Y/75/18/L

The application is for the conversion of an existing outbuilding to ancillary accommodation to main dwelling.

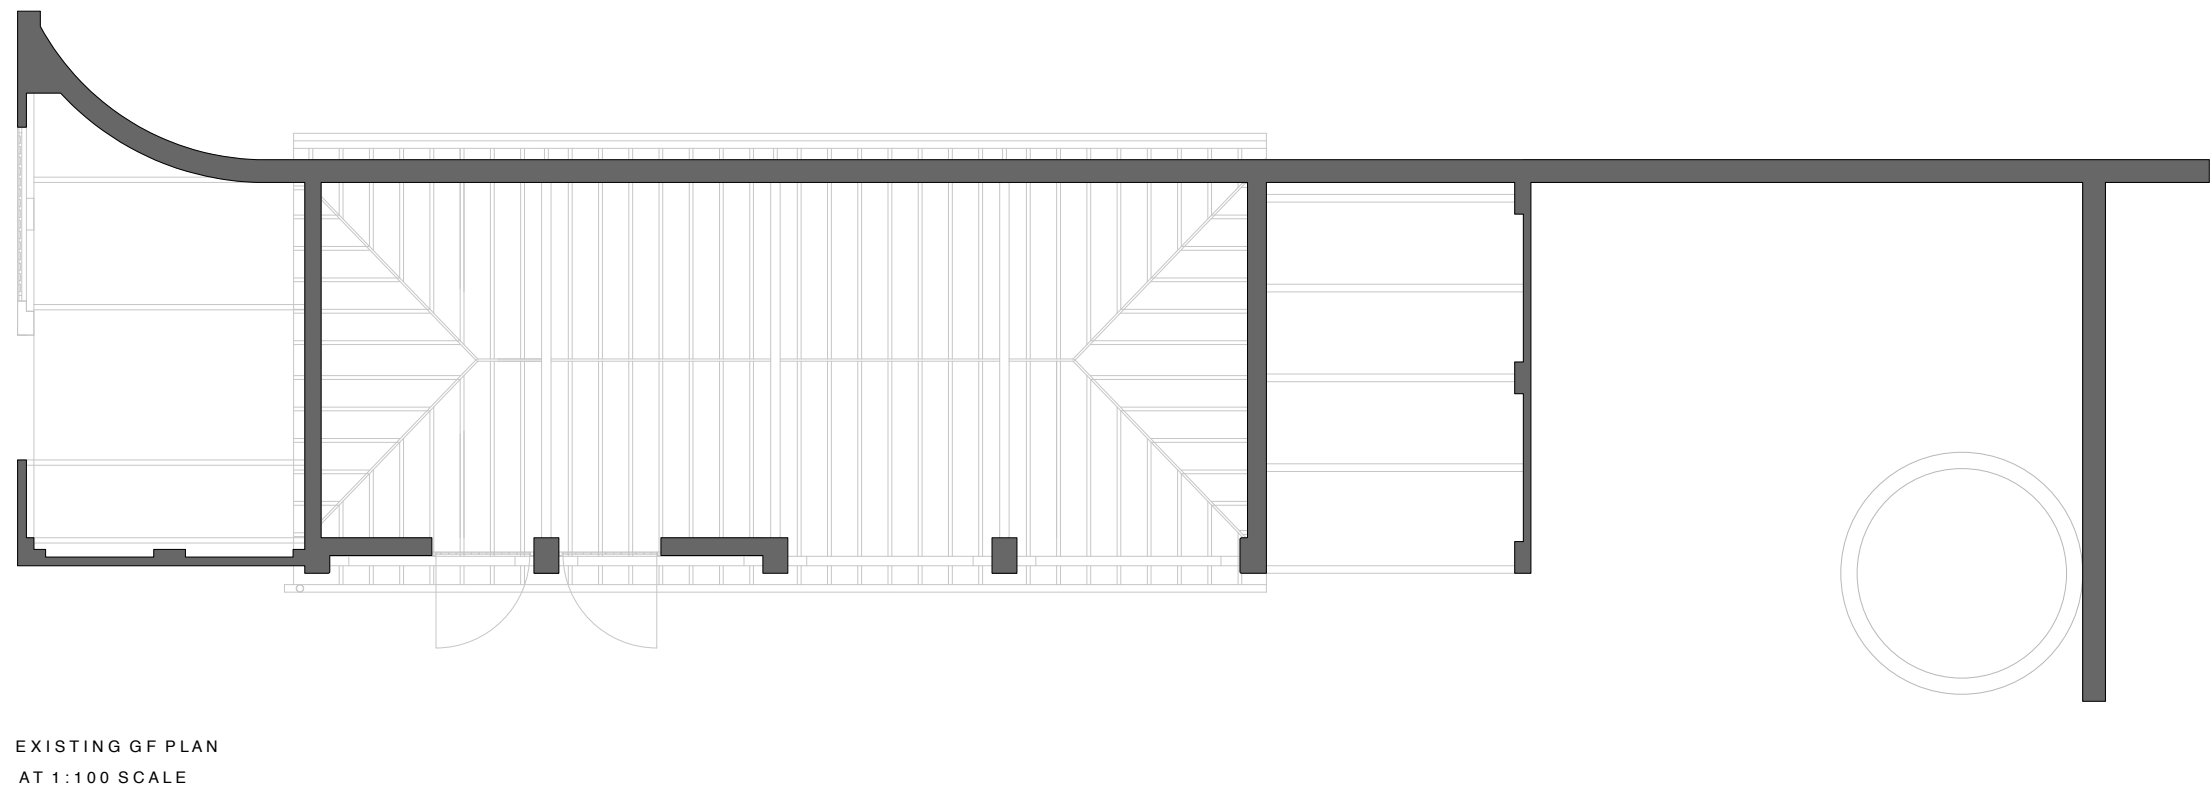
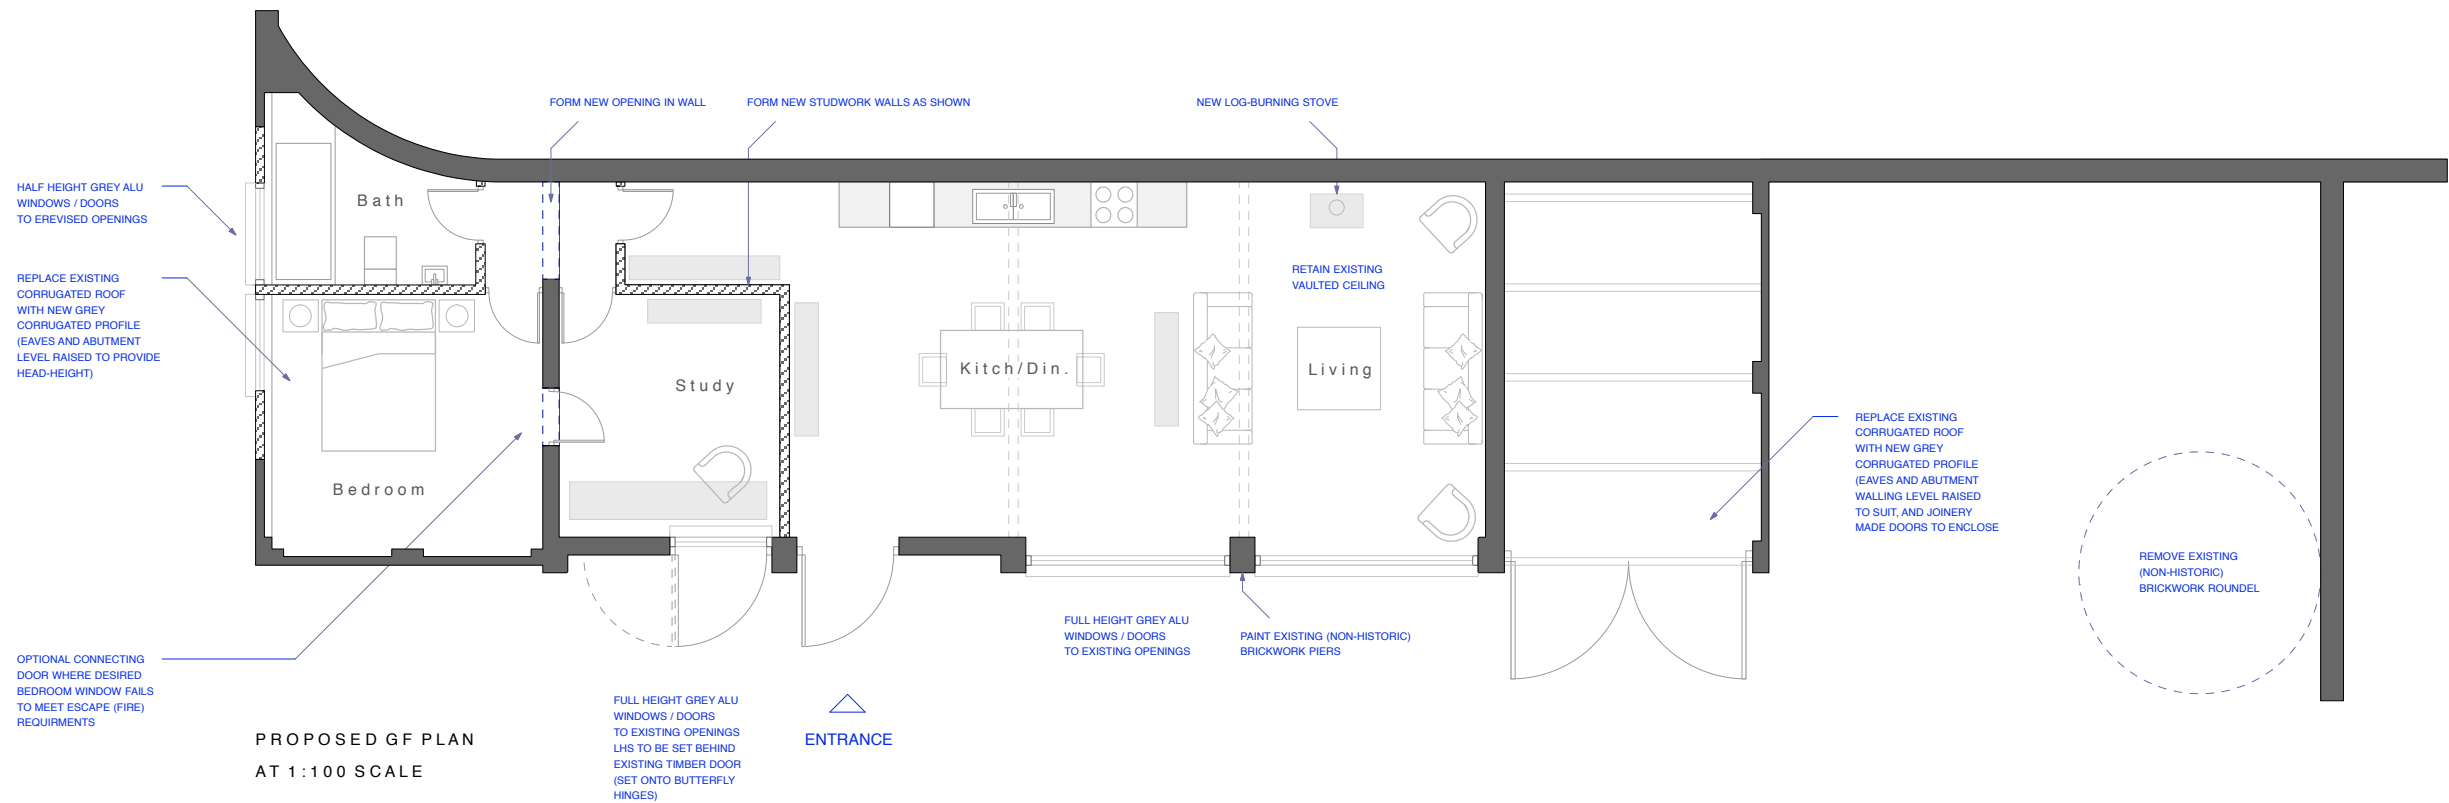
Materials have been identified in both the application form, and the floor plan of the barn. However, the level of detail is not very clear. As a consequence, if minded to approve the application, you should request the following:

- Details of windows/doors
- Confirmation of the details of the roofing materials – the application refers to ‘new corrugated metal sheeting to side components’, but nothing else
- Details of how the timber weather boarding will be treated

PROPOSED FRONT ELEVATION AT 1:100 SCALE
NORTH EAST

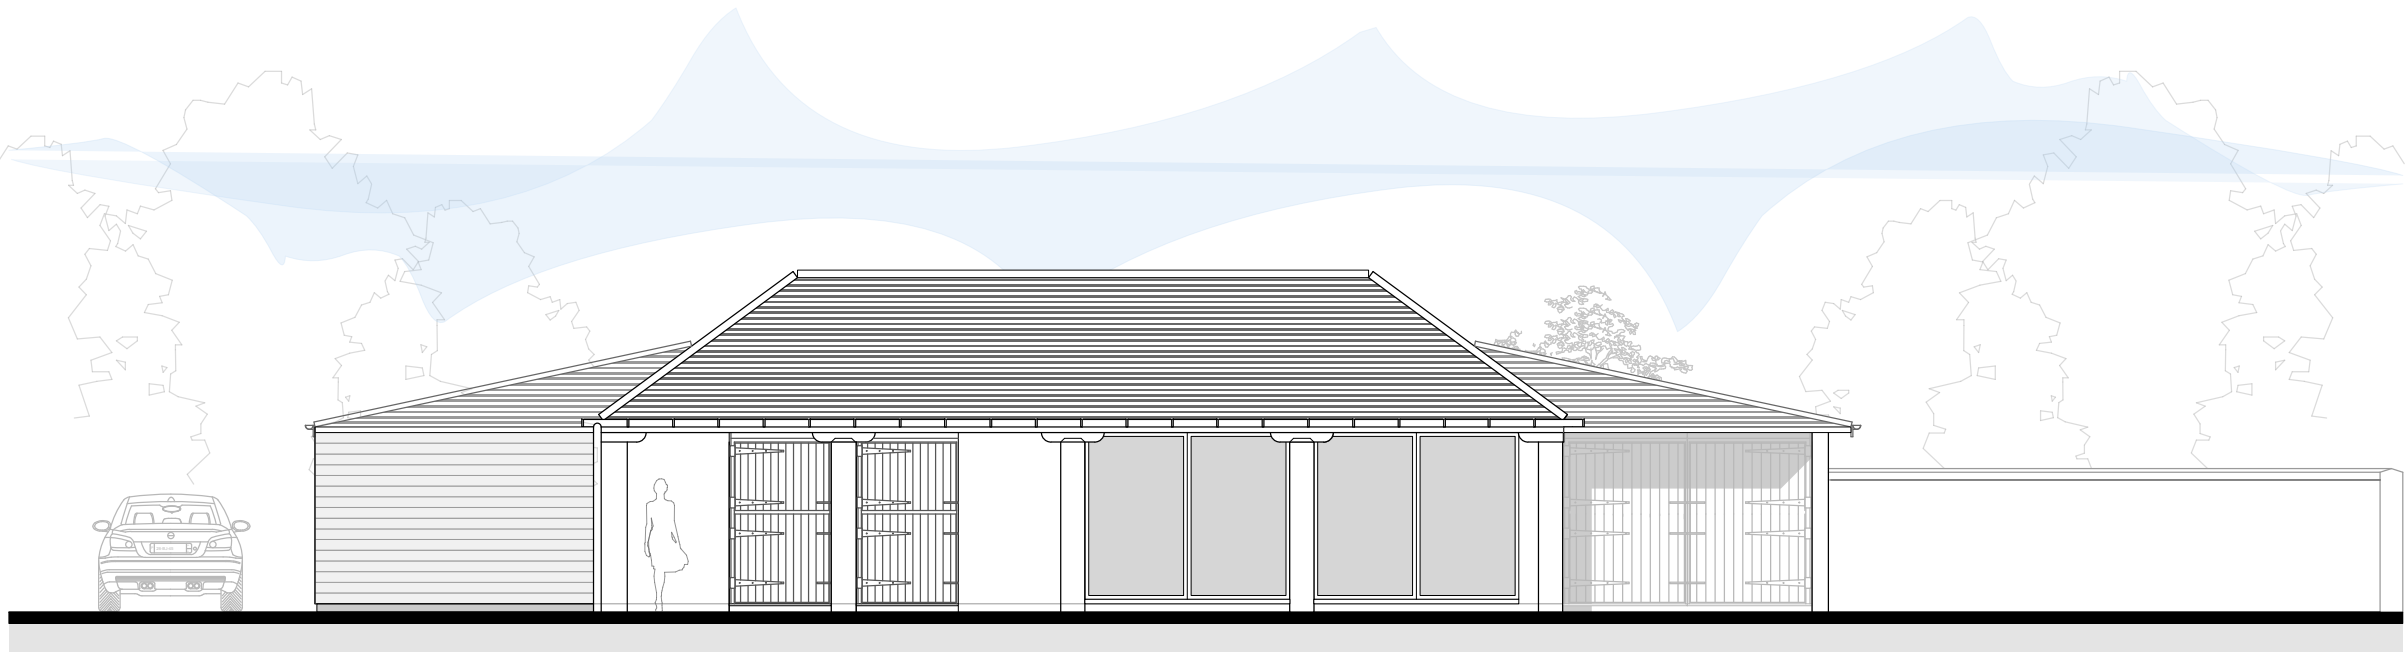
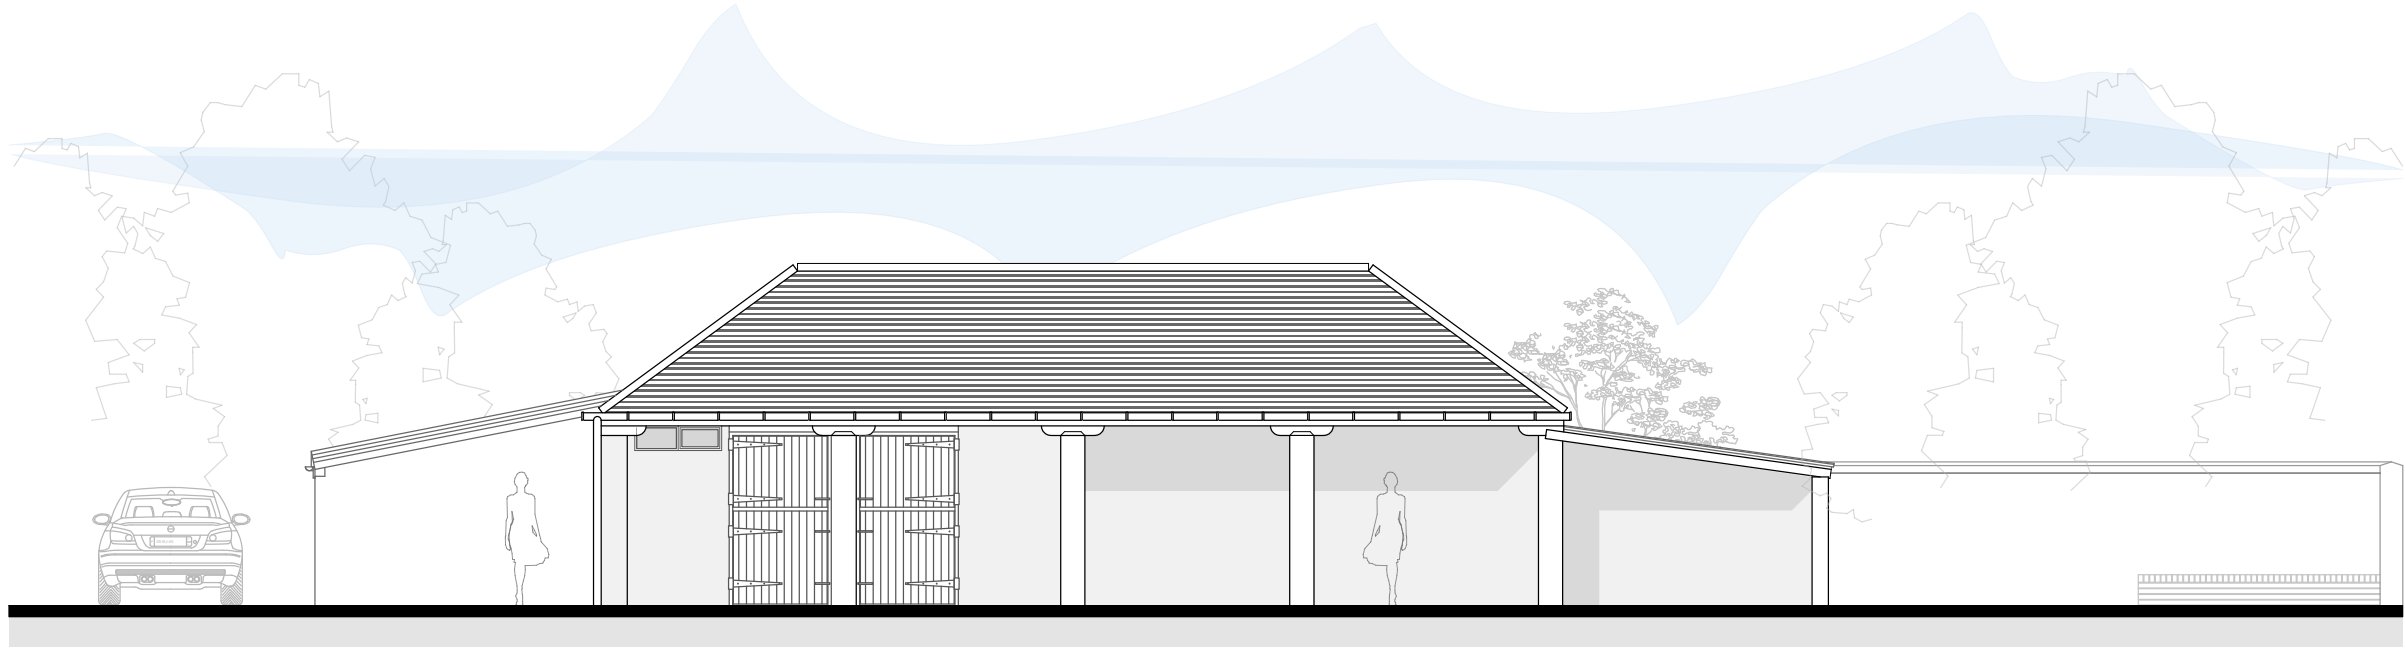
The use of aluminium windows are considered acceptable as they can actually be more discrete than solid wooden ones, subject to the details of the windows/doors – the frames should be minimal and discrete. This approach is supported by the relevant Historic England Guidance.

I note that the proposal is to maintain two existing timber doors as an attempt to reduce the impact of the glazing. Such an approach maintains the traditional appearance of the structure, and can be supported.

However, the glazing in all of the existing openings (doors and cart) should also be set deep in the reveal of existing openings. This creates shadow lines and minimises reflections and impact upon the character of the building.
